Our Ref: M/105/19/HH
Your Ref:

Town & Country Planning Act 1990 (as amended)
Town & Country Planning (Development Management Procedure) (England) Order 2015
Application for Planning Permission for Works or Extension to a Dwelling

Development Removal of existing porch and erection of new front porch.
Location 20 Lane End Road Middleton on Sea

north

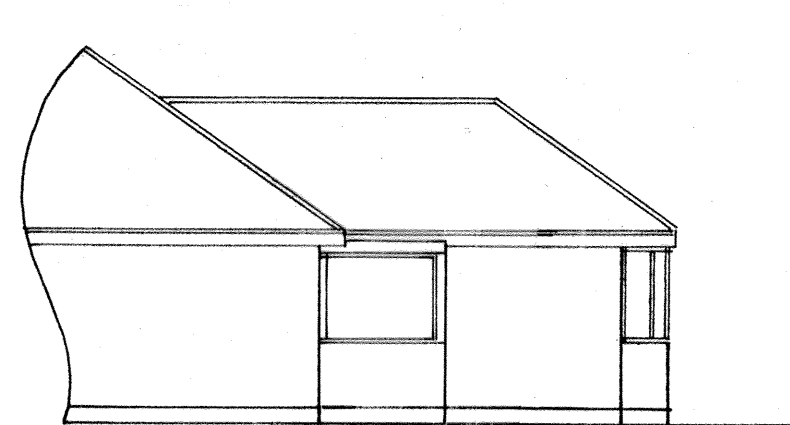
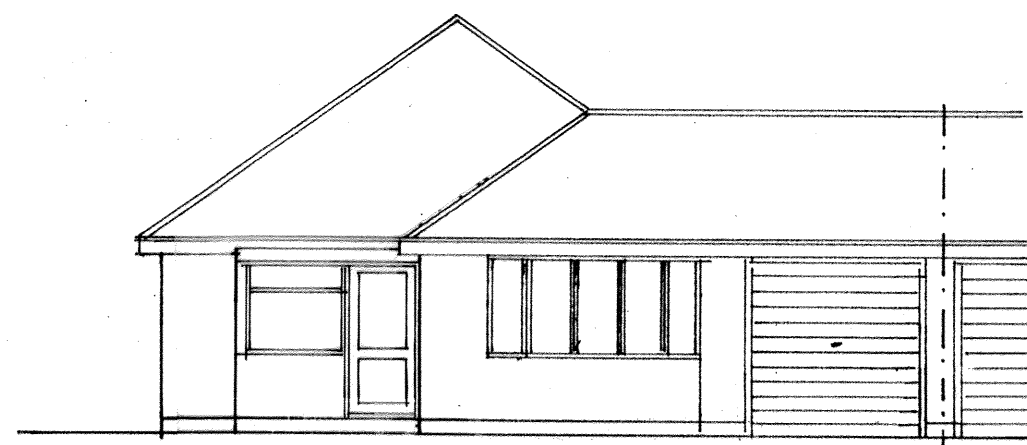
The existing and proposed North and West elevations have been labelled incorrectly. Please amend accordingly and re submit.
